# DORAN DRIVE PRECINCT

## MIXED USE DEVELOPMENT

DESIGN EXCELLENCE REPORT  
DEVELOPMENT APPLICATION SUBMISSION

19<sup>TH</sup> JULY 2021  
REVISION H

1 North Elevation Podium  
1:200

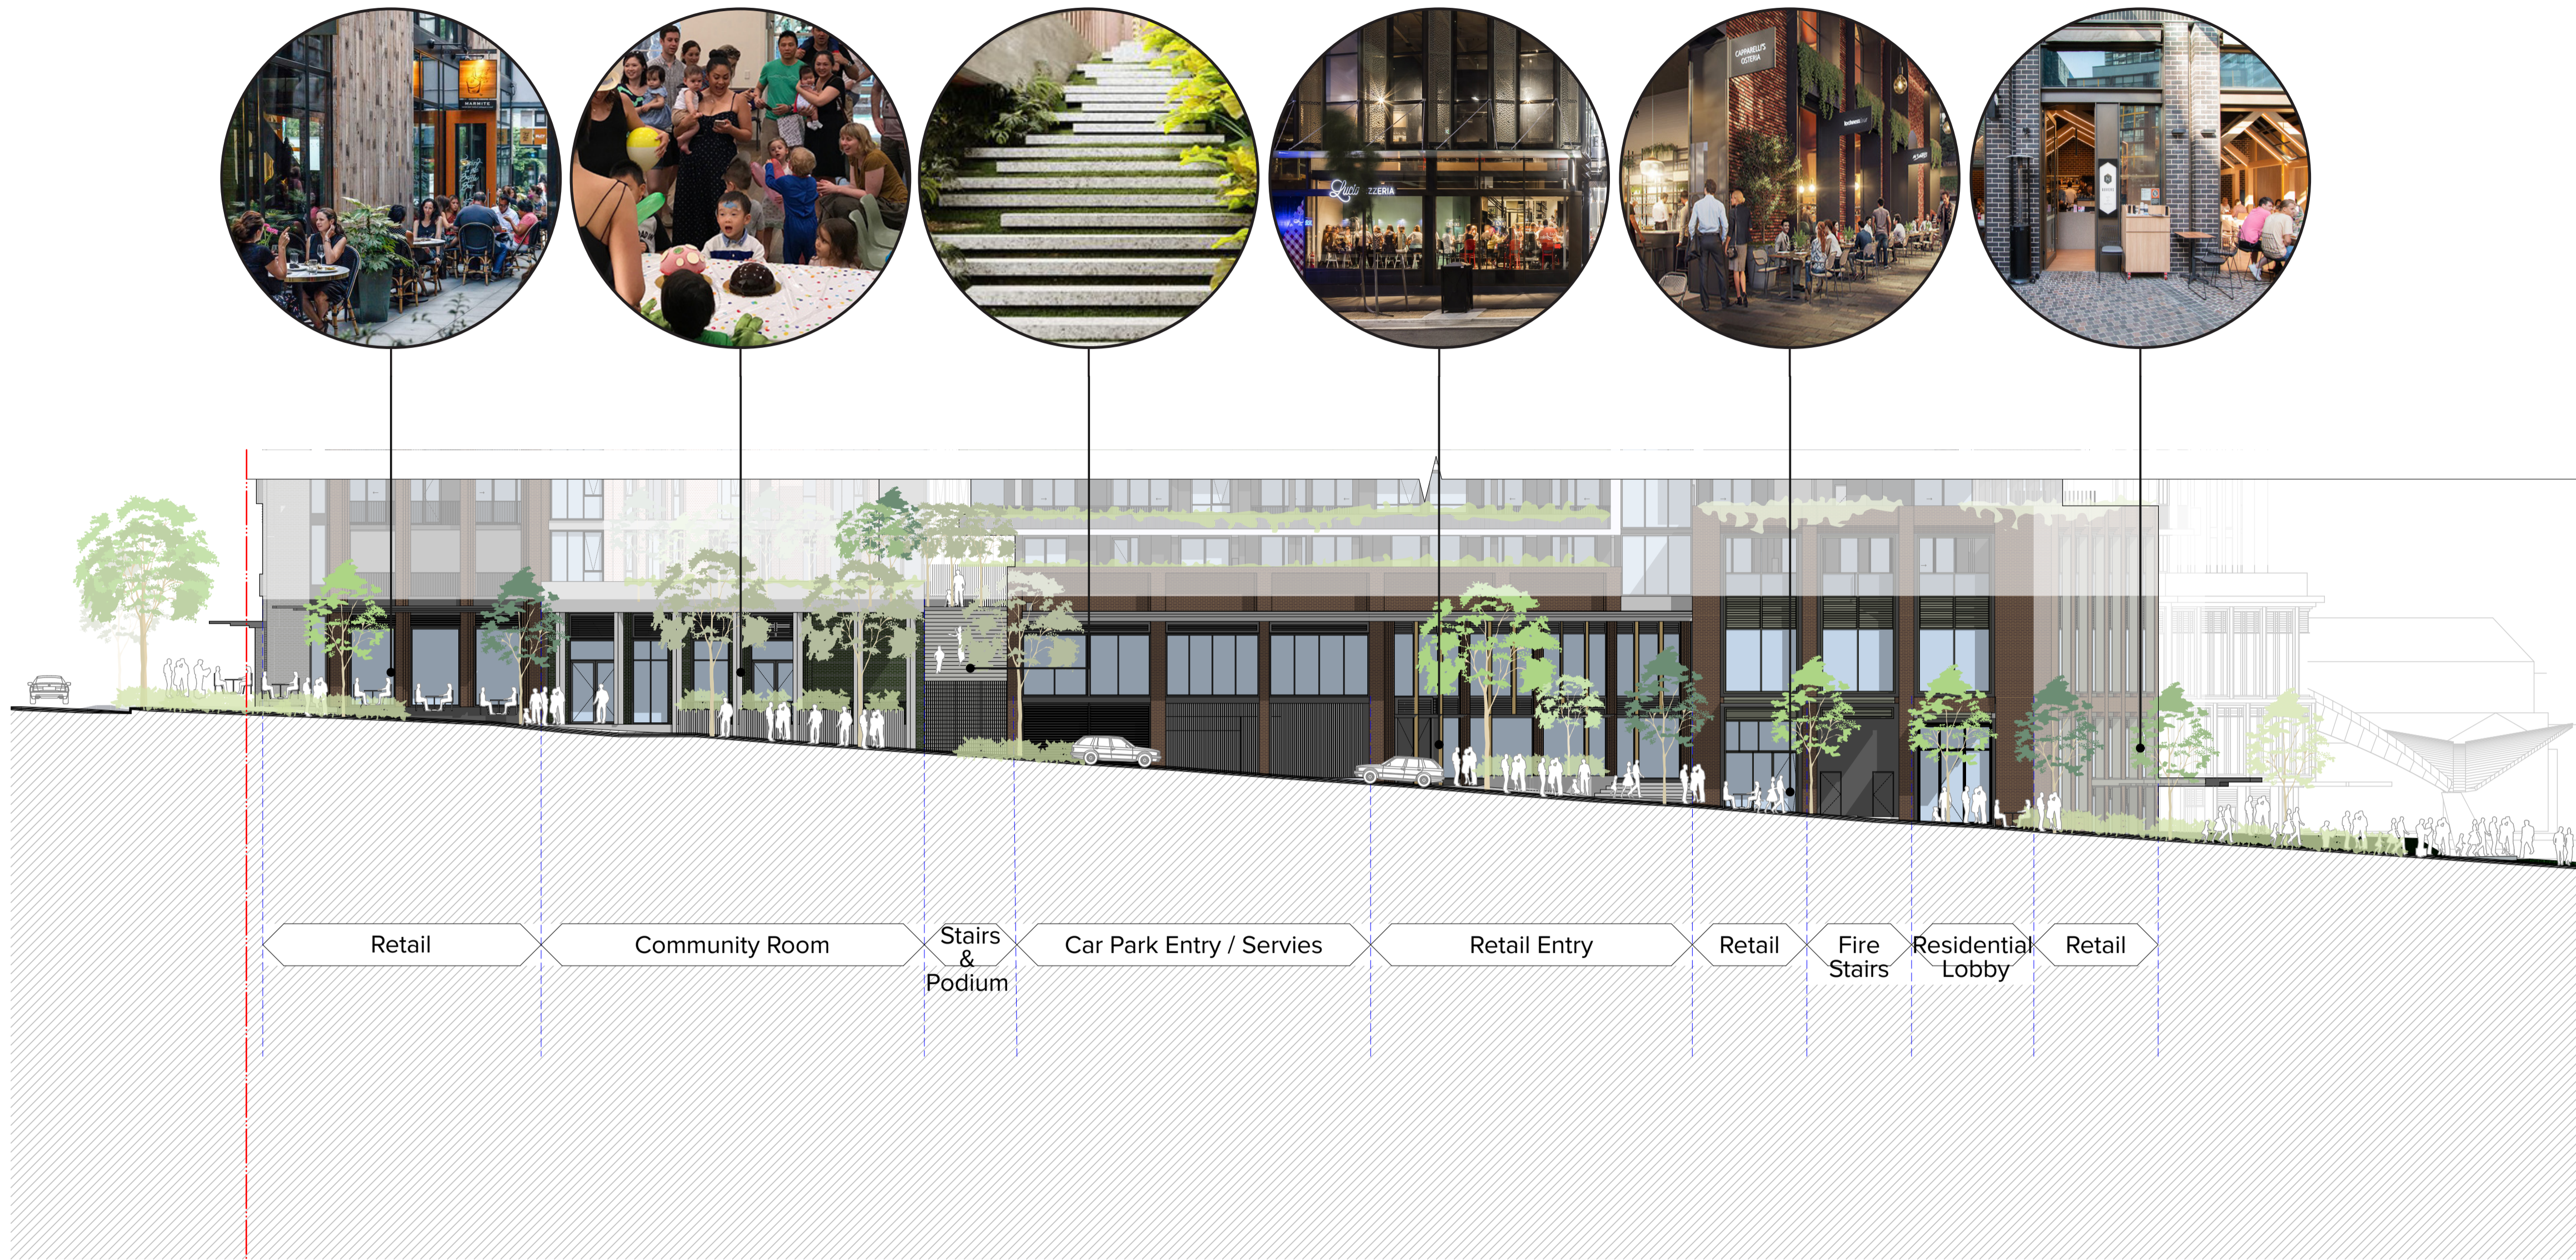
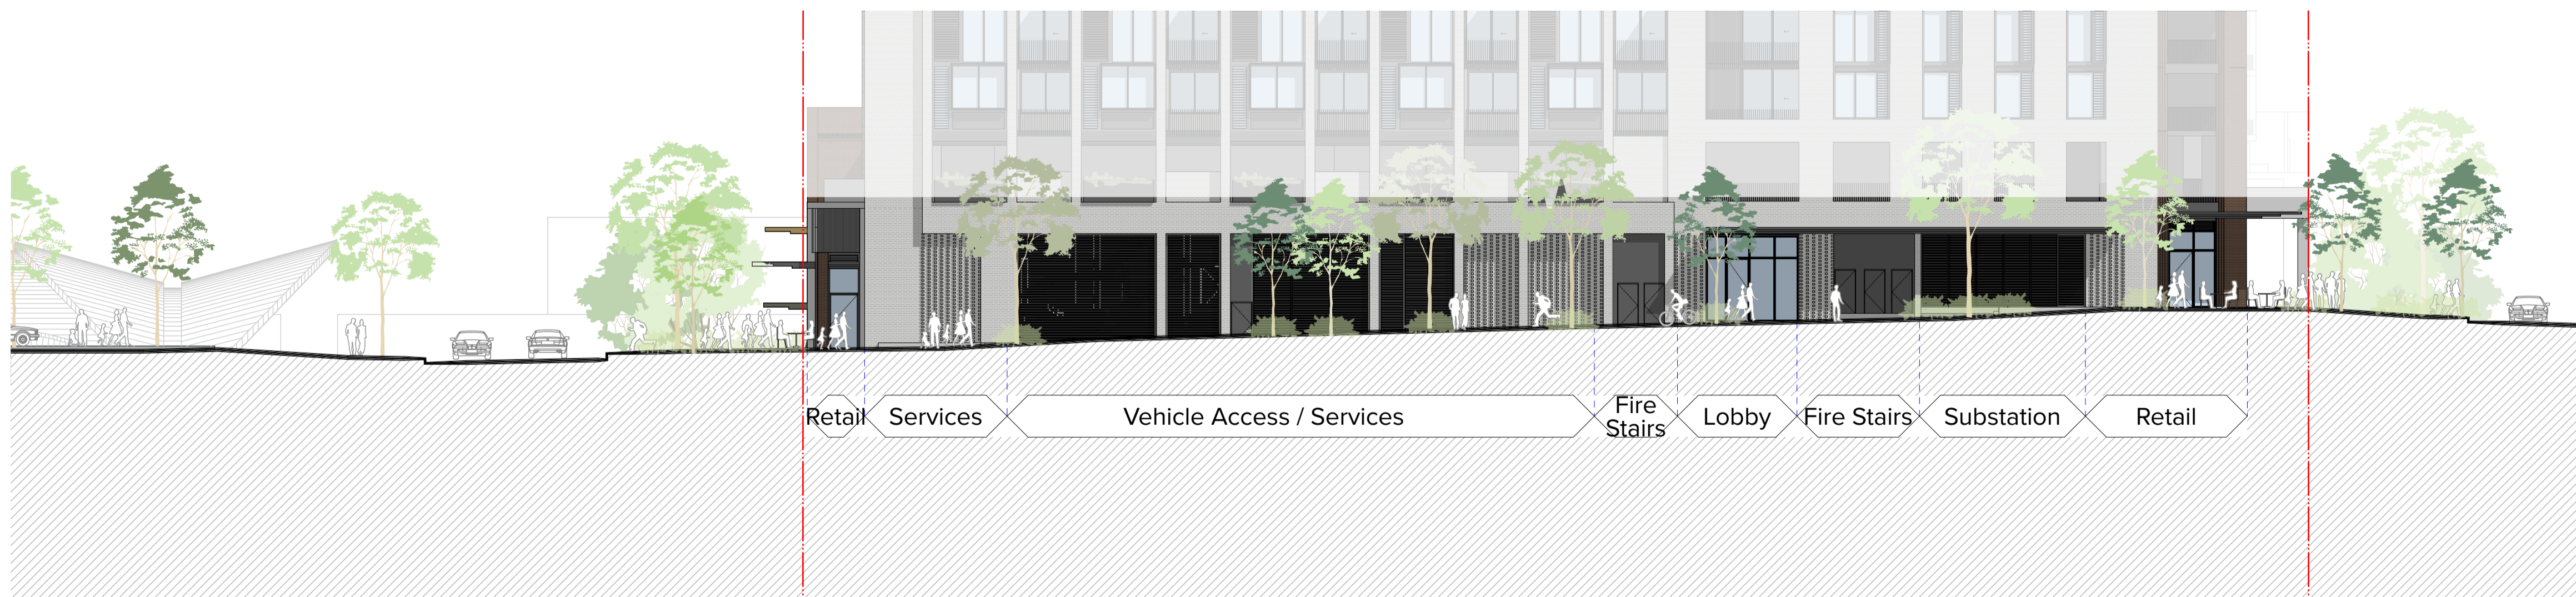
*"The tower forms on the NE and SW corner present sheer unobstructed frontages to prevailing winds and are likely to generate considerable turbulence at street level. Provide wind studies to demonstrate suitable pedestrian amenity at street level, and strategies for ameliorating unacceptable impact."*

topography of the site. This mitigates the impact of the supermarket (which occupies just a short length of the street façade), creating a continuous activation along this streetscape. De Clambe Drive similarly deals with the steep topography of the site through a stepped integrated interface of retail and other active uses, as well as providing a tertiary entrance to the retail precinct on level 01.

The scheme is cognisant of the need to mitigate wind, and the collaboration of the design team and wind consultant ensures suitable comfort levels are achieved at street level and other key areas. There are continuous awnings around the perimeter of the development to provide sufficient protection. This is further assisted by the generous 50% tree canopy coverage provided within the landscaping, and by placement of entries, outdoor dining, and other active uses in appropriate locations.

1  
-  
South Elevation Podium  
1:200

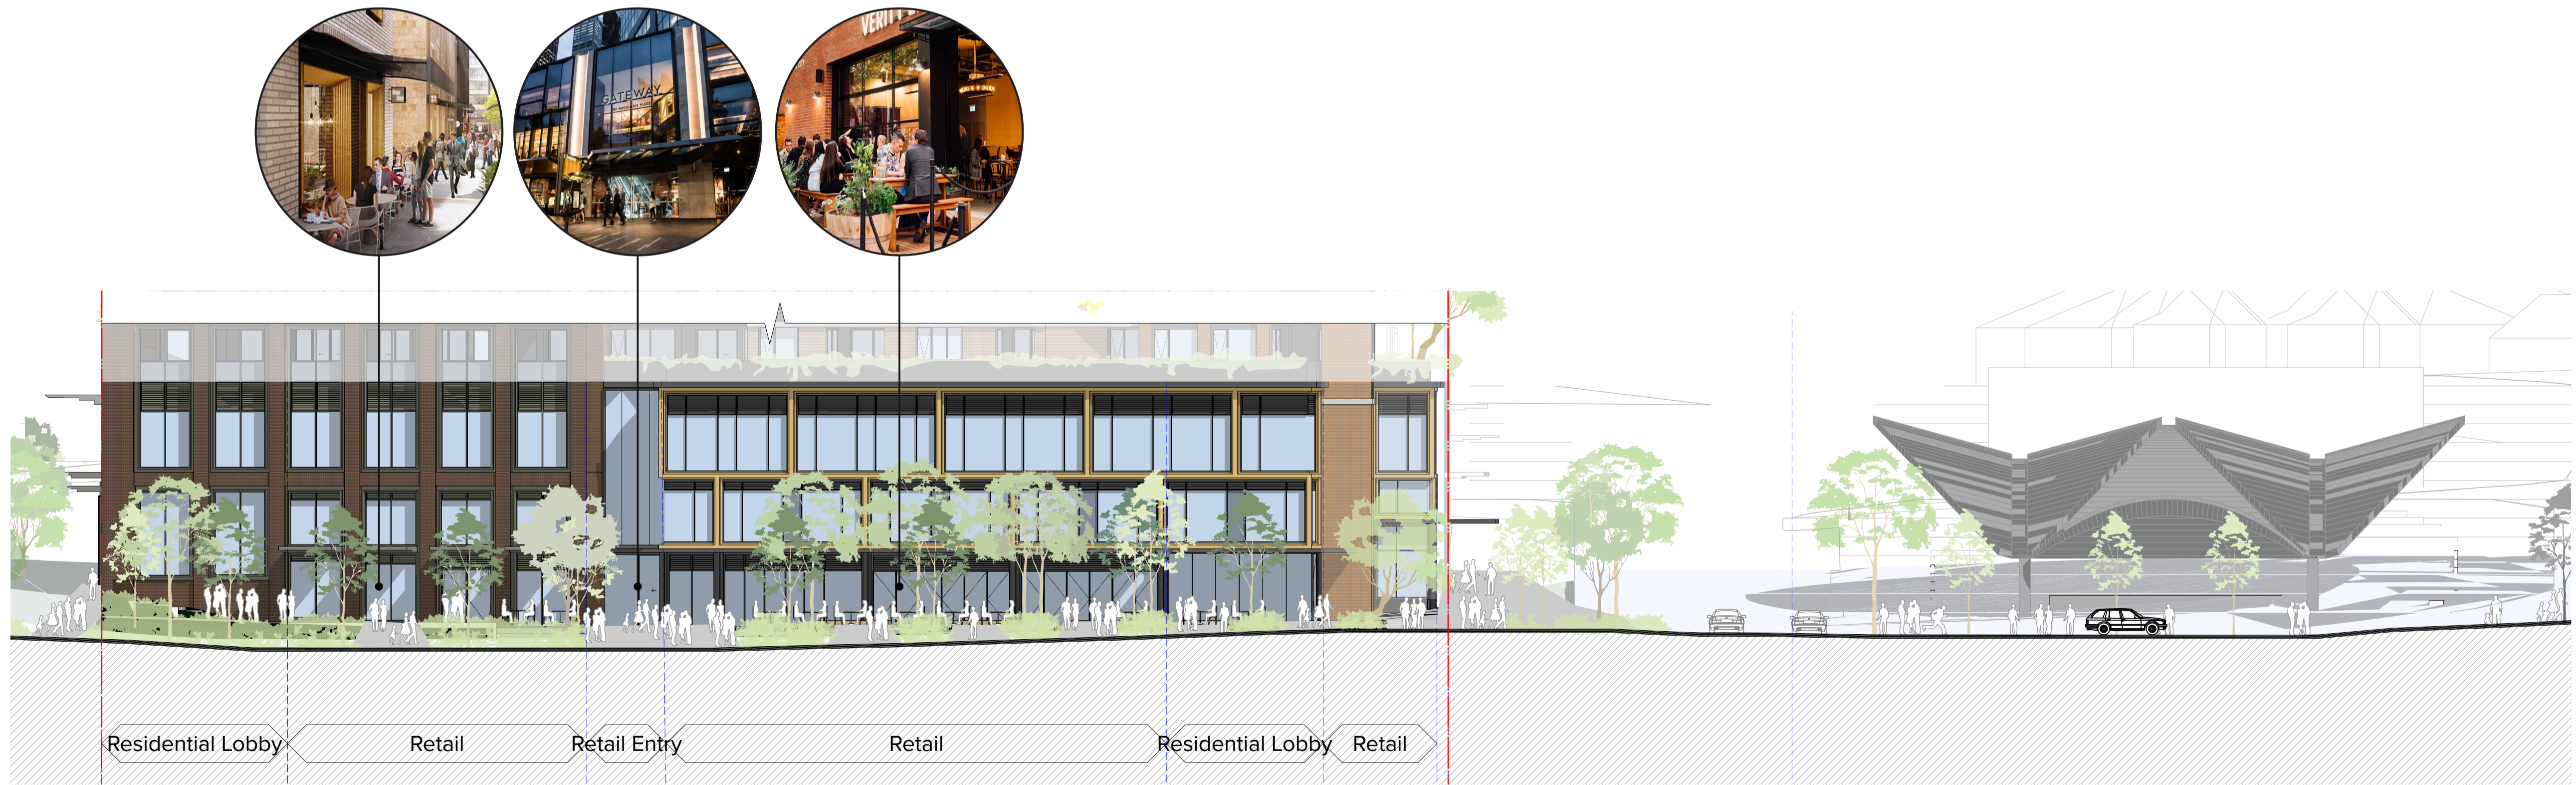
*"There is minimal activation along Mandala Parade as a large portion is a single supermarket frontage, which is not even accessed from the street. This further reduces the activation to Station Plaza. Consider stepping the ground floor slab levels to better follow the natural slope of the street and provide for multiple entry points along the street."*

*"The proposal only allows for awnings at the entry points on Mandala Drive. Provide a continuous awning to Mandala Drive to improve amenity along this frontage."*

Along Mandala Parade, a fine-grain retail offering with multiple entry points is achieved through the proposed stepping of the residential lobbies and retail tenancies aligning with the
